June 21, 2024

**RE: Honeywell
9201 San Mateo Blvd.
TRAFFIC CIRCULATION LAYOUT - RESPONSE TO COMMENT**

Per the correspondence dated June 20, 2024, please find the following responses addressing the comments listed below:

(1) HC PARKING DETAIL
SCALE: NTS

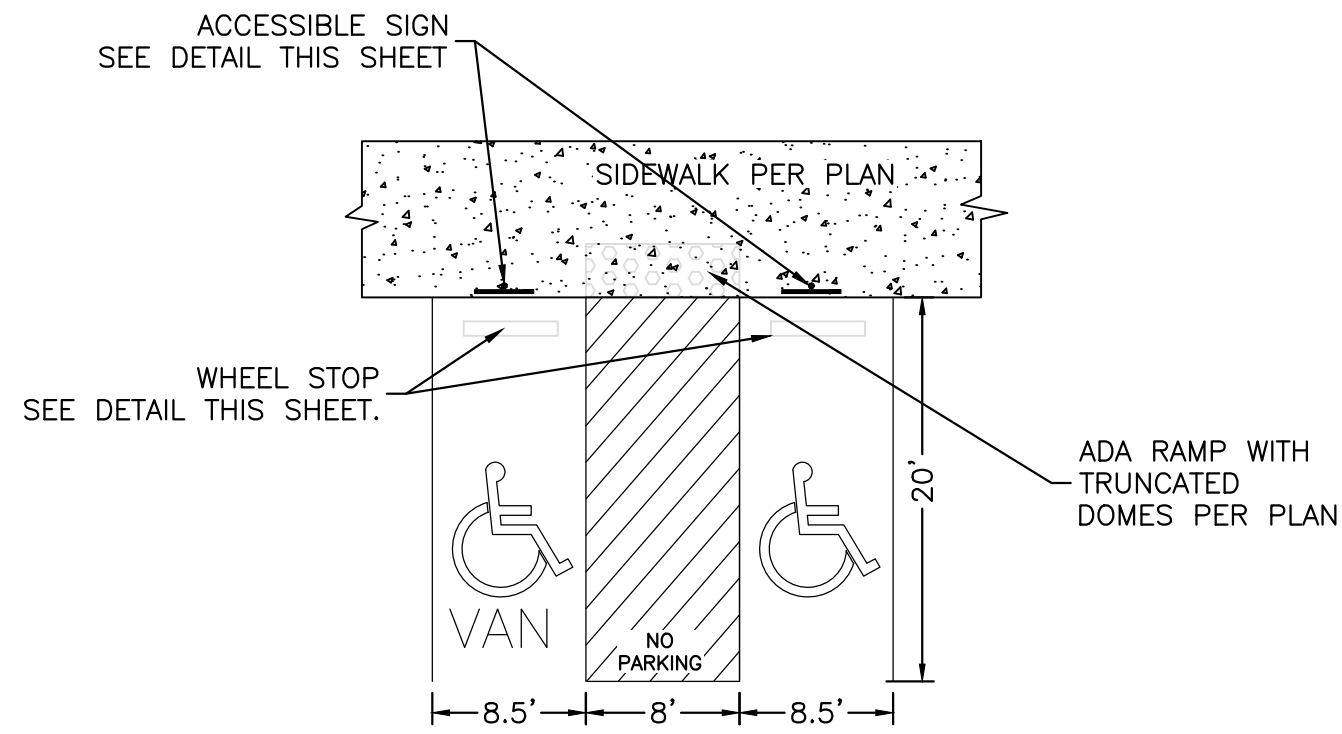
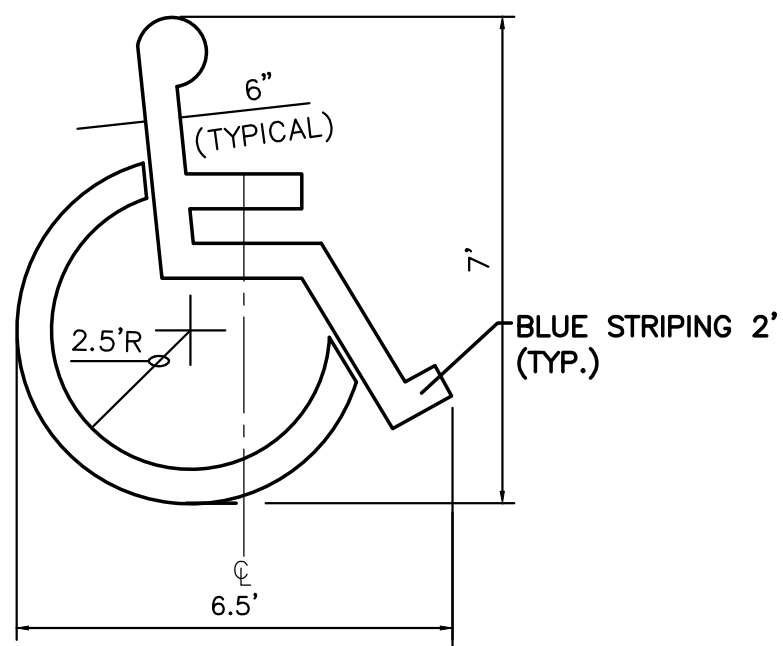
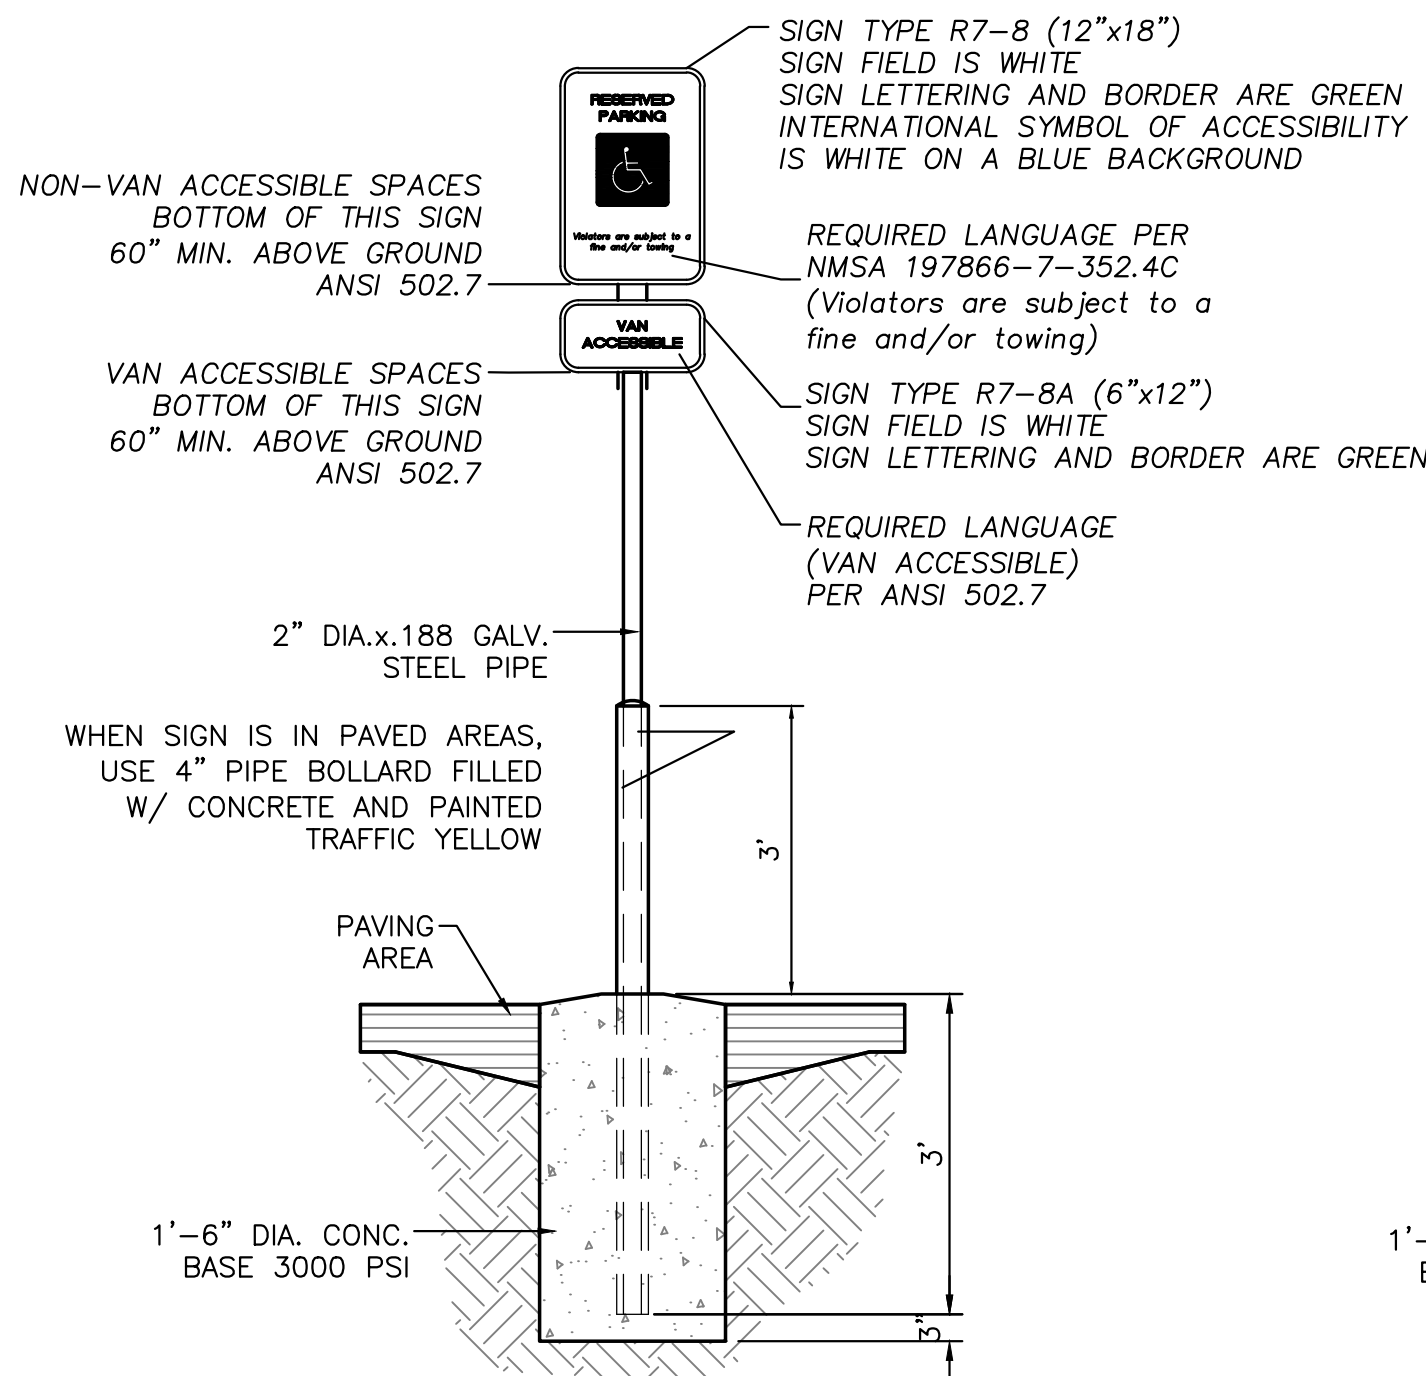
1. **Comment:** Prior to approve the TCL for the project mentioned above, please show on the site plan the all proposed 36 Motorcycle spaces, and clarify, why the keynote 11 refer to the ADA parking?

Response: I recounted and there are actually 40 MC spaces. I noted the mount at each location and with a keynote. The Keynote 11 at the ADA spaces was supposed to be key note 17 for the accessible pathway. I updated the plan to reflect that.

BIKE RACK DETAIL
SCALE: NONE

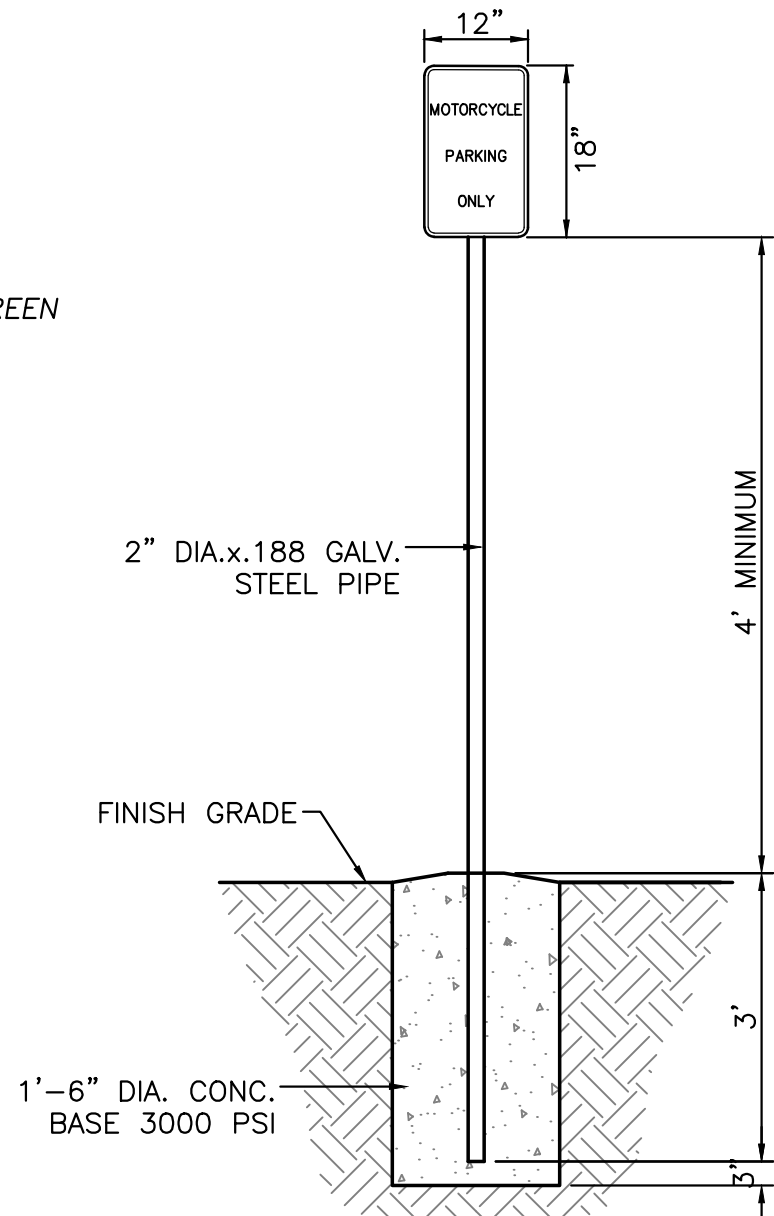
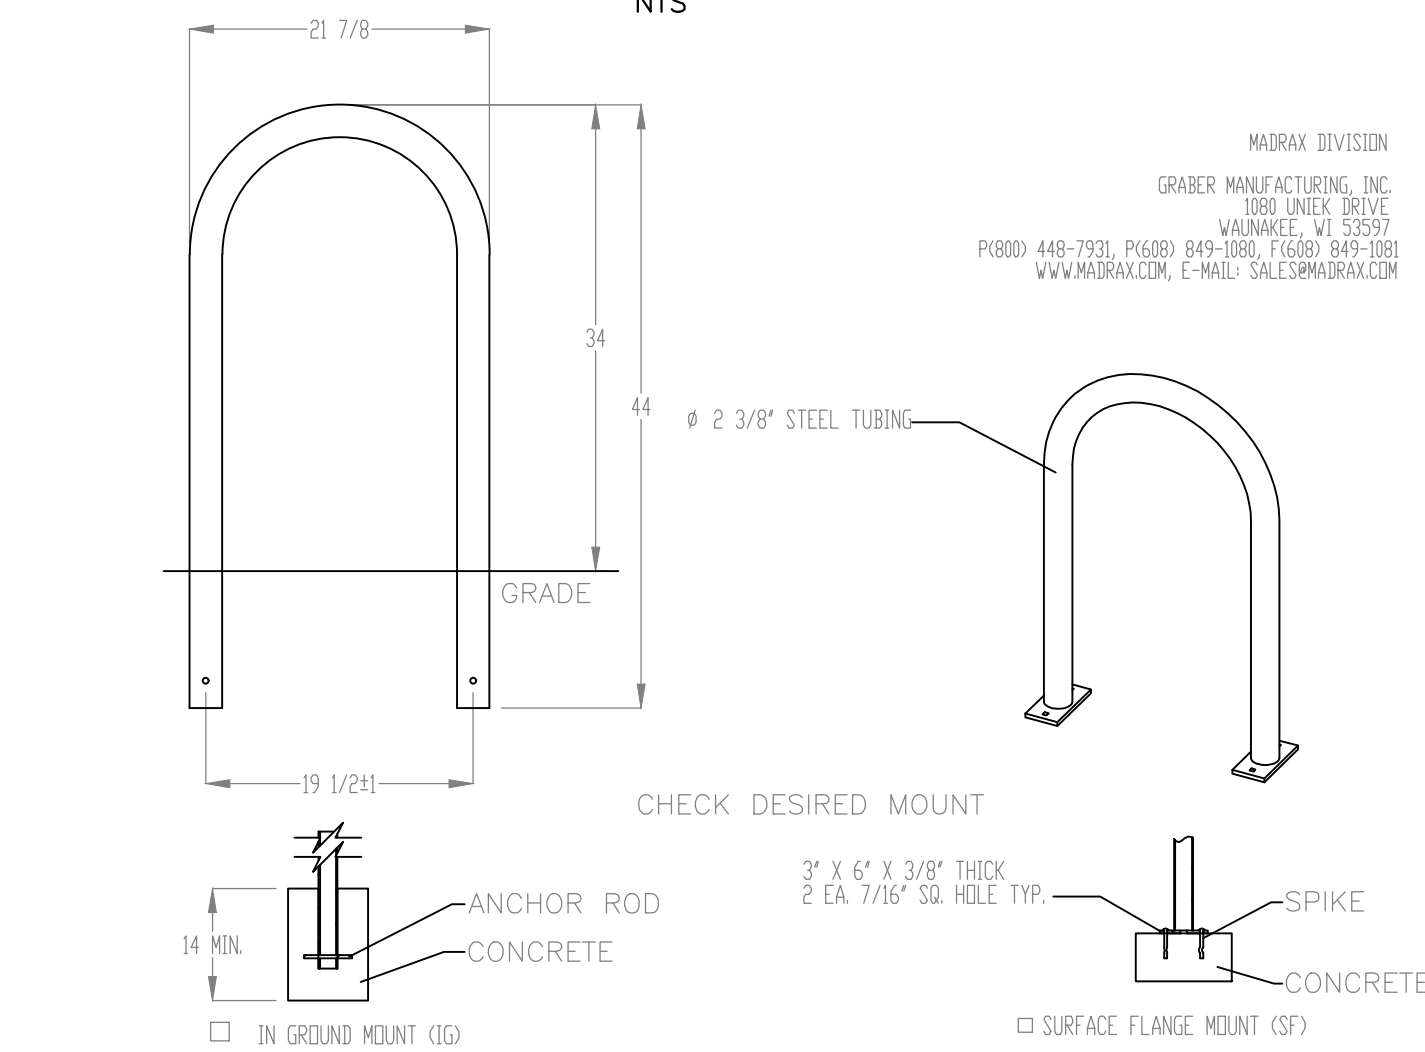
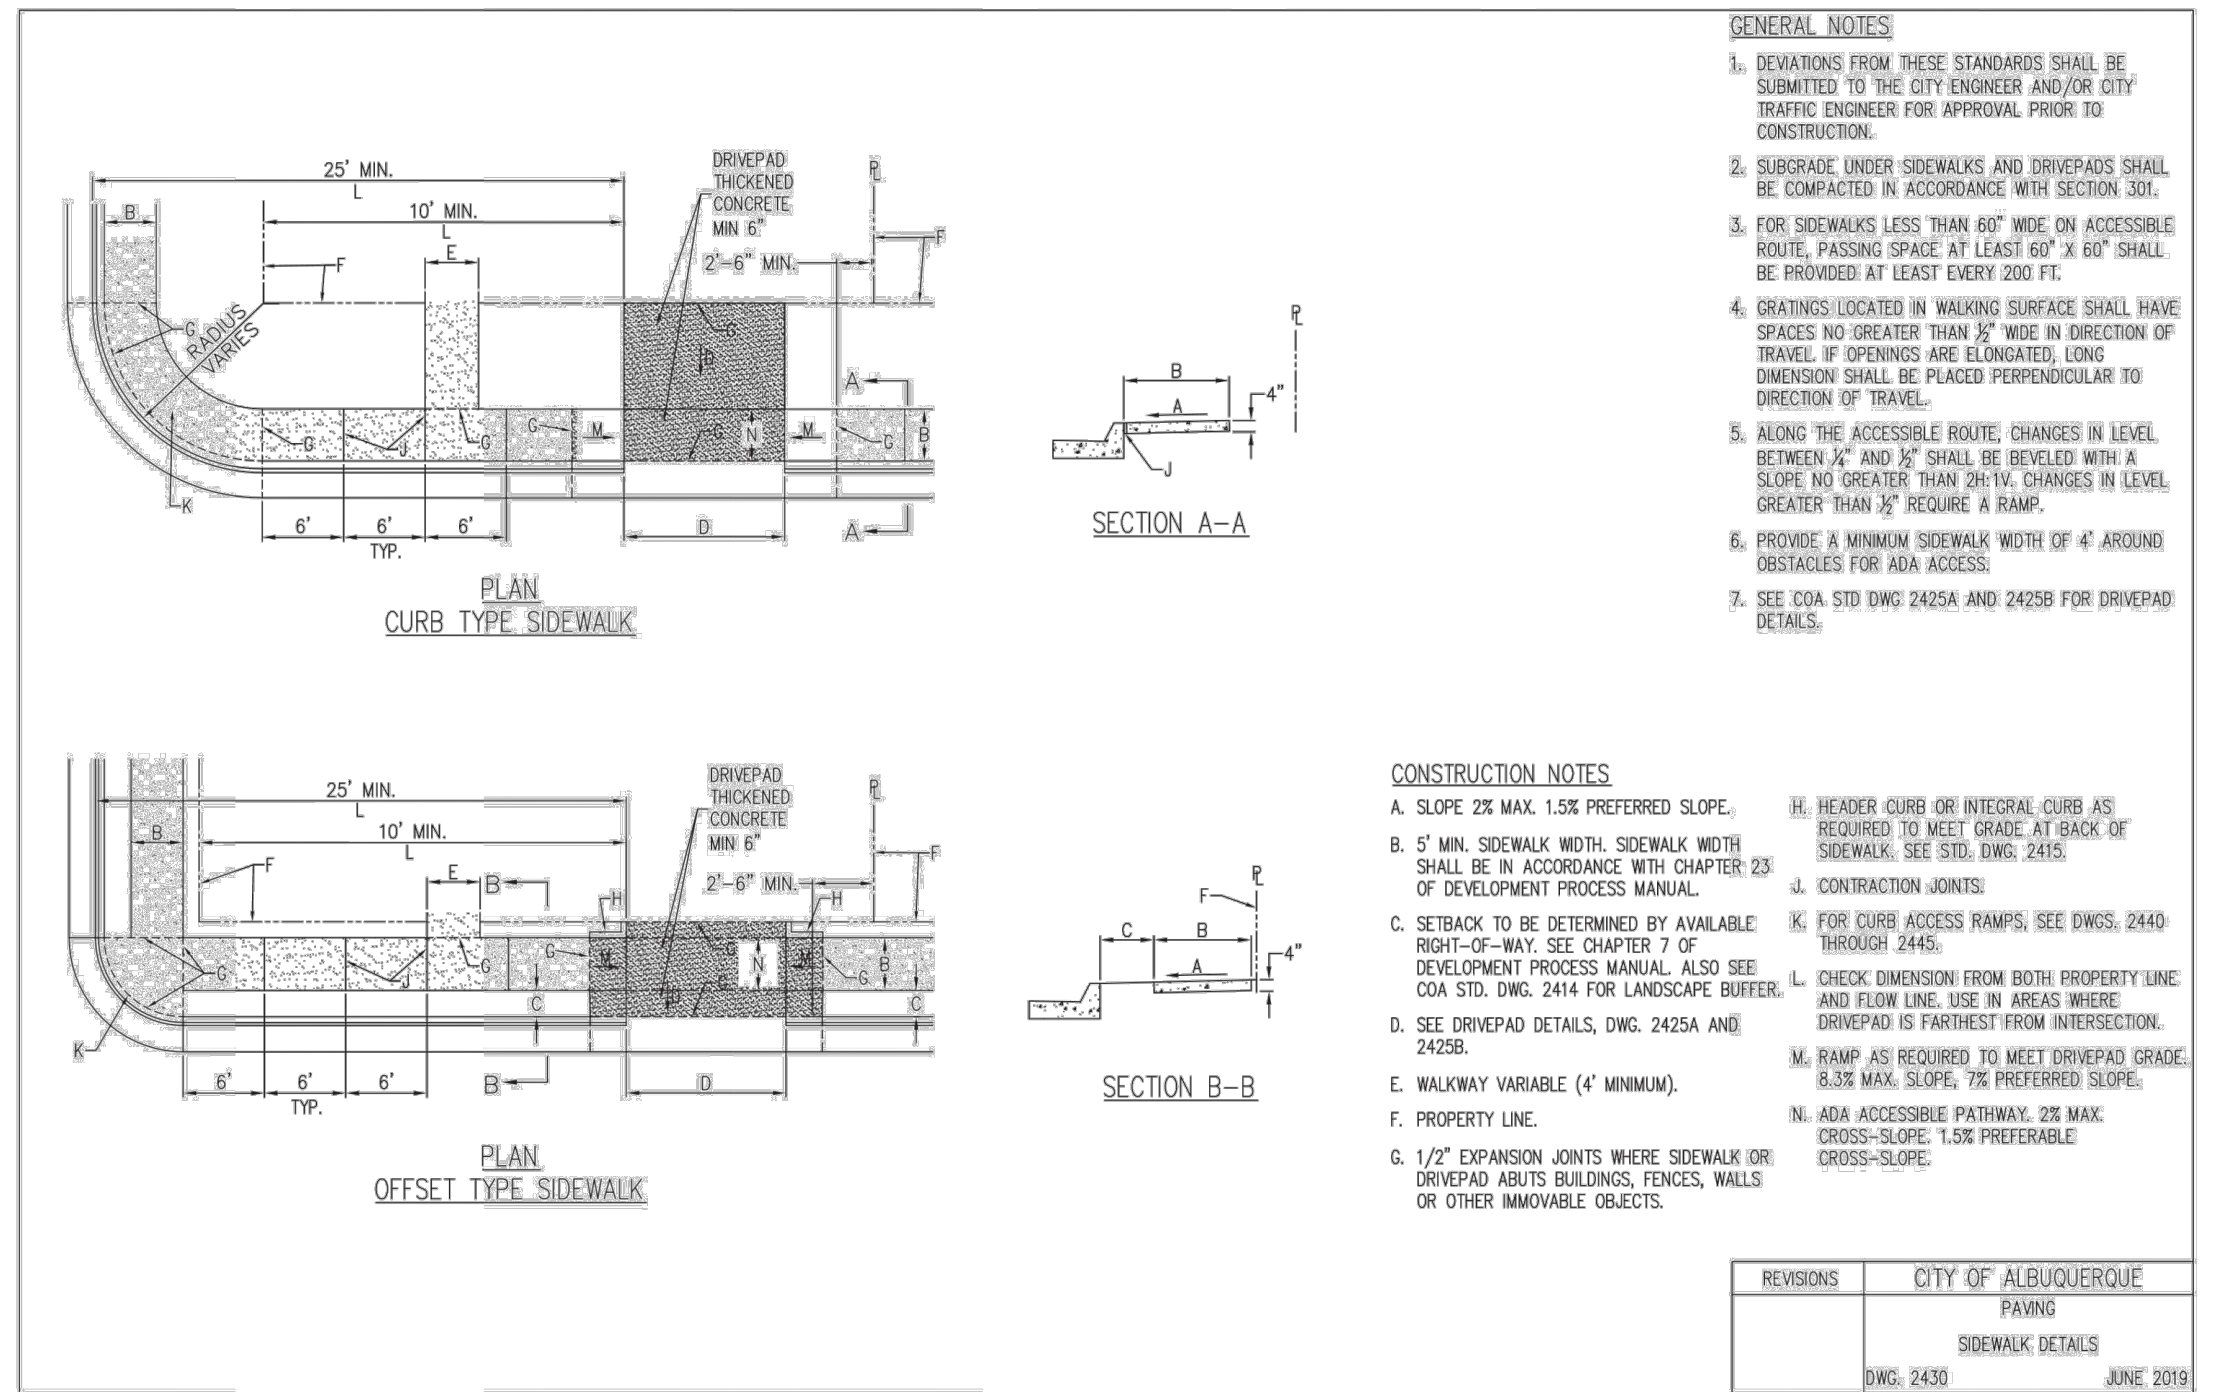
2. **Comment:** Also, please see attached Bike Rack requirements. Note that it is acceptable to keep the existing wave-style bike rack, but any new racks must comply with the requirements. Work within the public right of way requires a work order with DRC approved plans. Please add a note on the plan stating "All improvements located in the Right of Way must be included on the work order."

Response: All new bike racks were updated to have a 4 ft spacing between bikes and a 1 ft clear space as stated in the DPM. A bike rack detail was added to sheet C5.0.

A note was added to the site to state that all existing bike racks can stay but all new bike racks must comply with the DPM. The work order was added to notice to contractor number 6 on plan.
